Re: Railway works and all works necessary to eliminate and, where necessary, upgrade seven numbered level crossings and carry out all associated and ancillary works along a 24-kilometre section of the Dublin to Cork Railway Line.

Re: Dublin to Cork Railway Line (Elimination and Upgrade) of Level Crossings between Limerick Junction and Mallow Order 2021

I am writing to you regarding the proposed Railway Order authorising CIE to carry out railway works at Thomastown level crossing, XC201.

PLAN VIEW 01
Scale (1:1000)
View Rotated 22° Clockwise

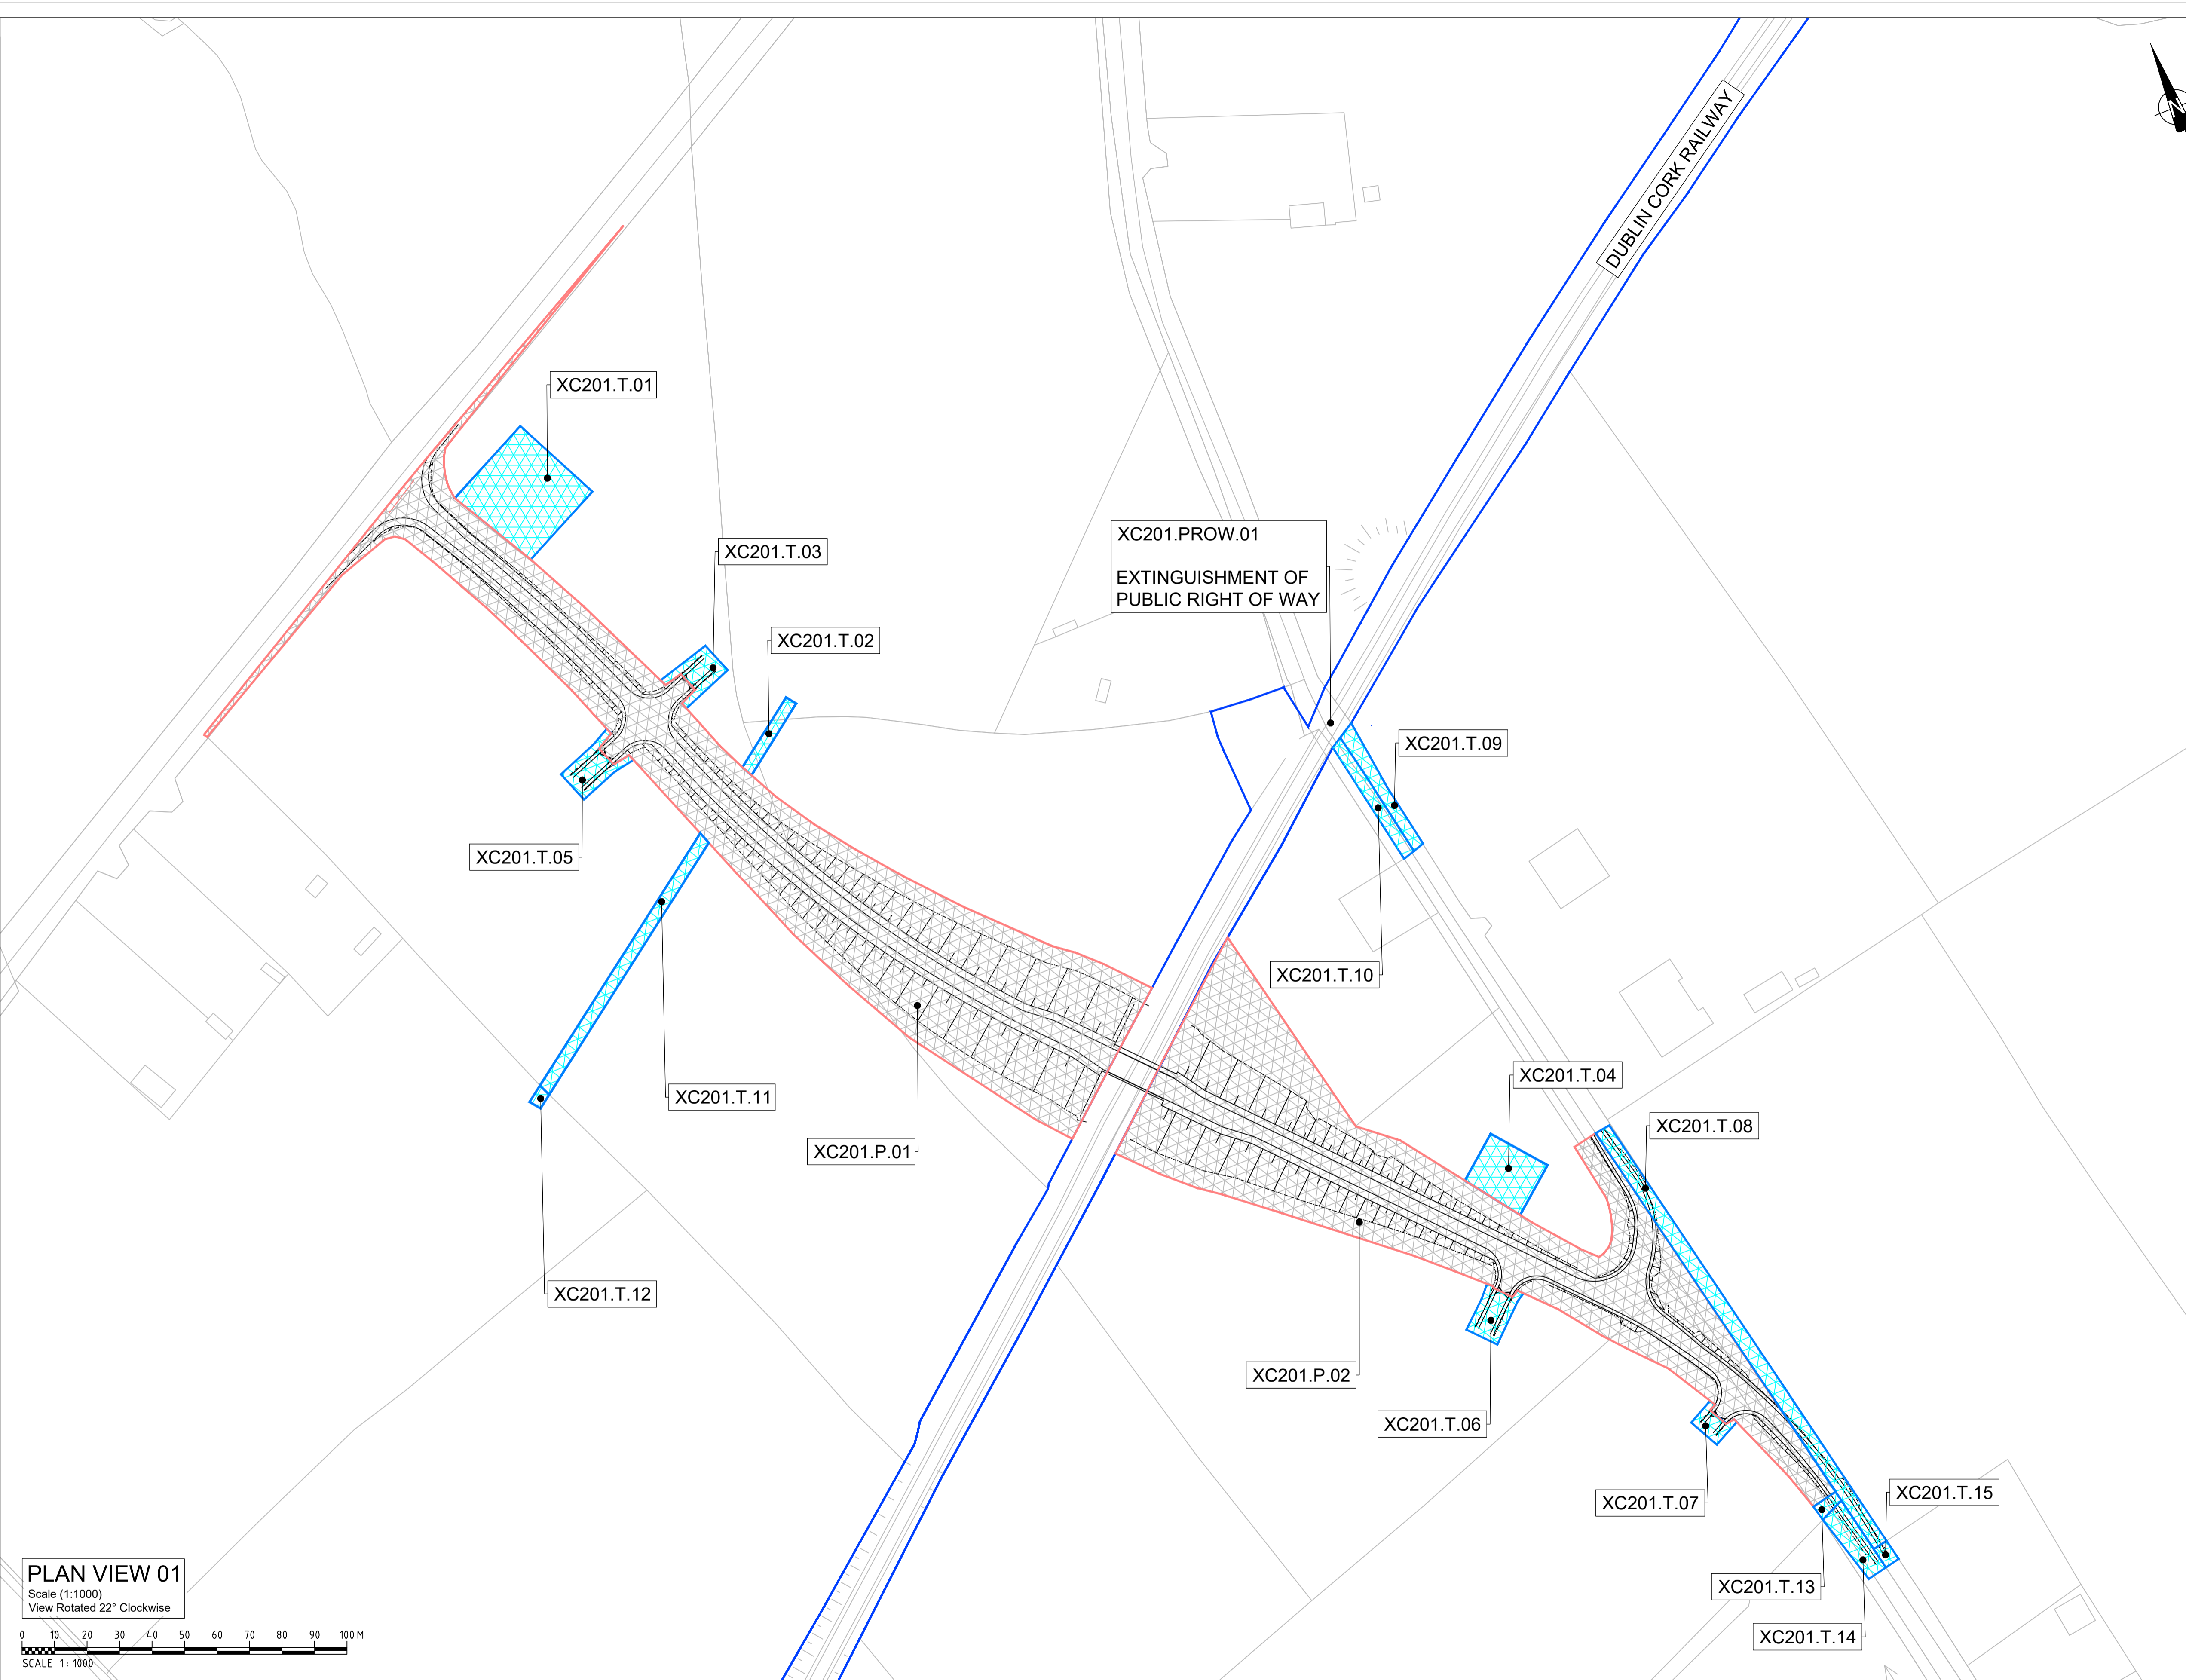
There is water exiting my property into the neighbouring property. Where the water exits into the neighbouring property will be under the new road development. I need to know what steps the engineers are taking to ensure adequate flow of water from my land to avoid water backing up into my drains and affecting the use of the land.

I also would like to know who will be responsible for ensuring the drains placed under the new surface will be maintained free, who to contact if there is an issue. If my land or the new road was to flood due to these drains being blocked, who is responsible?

I also have concerns regarding the removal of the road margin for what appears to be along 23m of my land. The best indication I can give of this area is along the point marked XC201.T.13 and XC201.T.14, although it's not exactly between these two points. I am concerned about this changing my ability to potentially build on that land in future or to put an agricultural or dwelling entrance at that point as it is at a point where an entrance could be more practical for me.
